INTEGRITY I.L.C. Services
Improvement Location Certificate
(This is not a property survey)

Site Plan Drawing_V1.pdf Markup Summary

FILE # AL-22-010

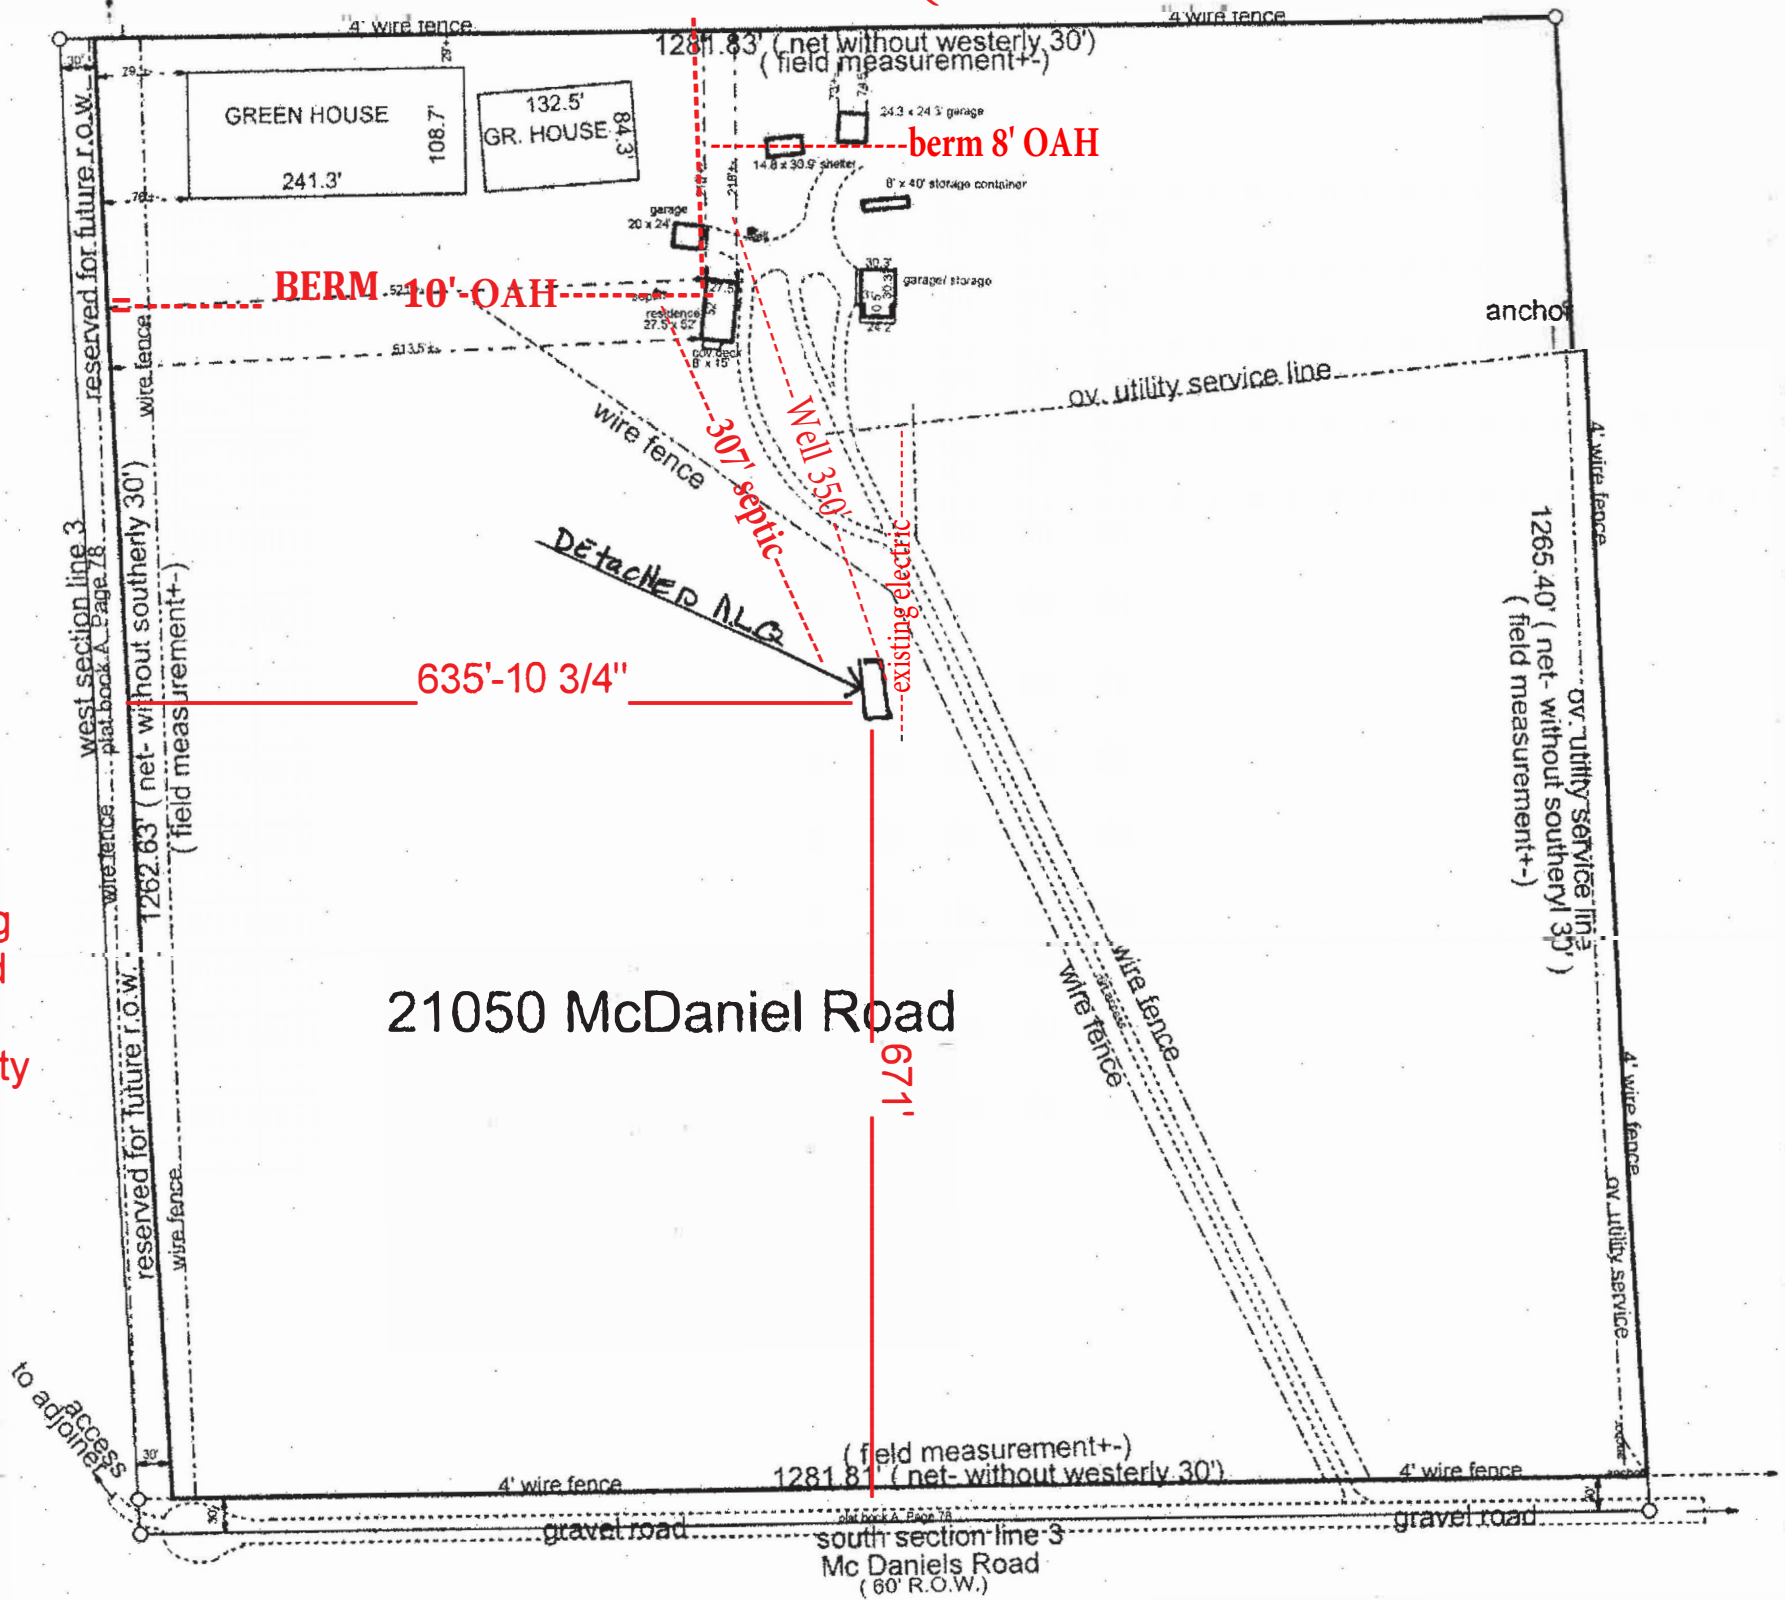
Remove this ILC reference

Add PCD File #
AL-22-010

Add following information
Add date
Owner name, address, phone #, email
legal description
Parcel # 3400000175
Zoning of property (RR-5)
Lot area 38.94 acres

Provide the proposed use, floor area, and height of the new Detached ALQ. The set backs of all building dimensioned from all property lines.

Annotate berm

Show location and height of berms.

Show approx distance of ALQ structure to property lines

-Show proposed OWTS (septic system)
-Show utility line
-Show water line or explain in LOI how water will be provided if new well etc
-Show size of the ALQ with dimensions

Show height of the wire fence. 4'?

Show location of all existing and proposed utility lines.

Provide percent of open space, landscaping and lot coverage, density and number of dwelling units.

Remove or cover this entire ILC reference and stamp. ILCs are not accepted. Above drawing may remain as "owner submitted site plan"
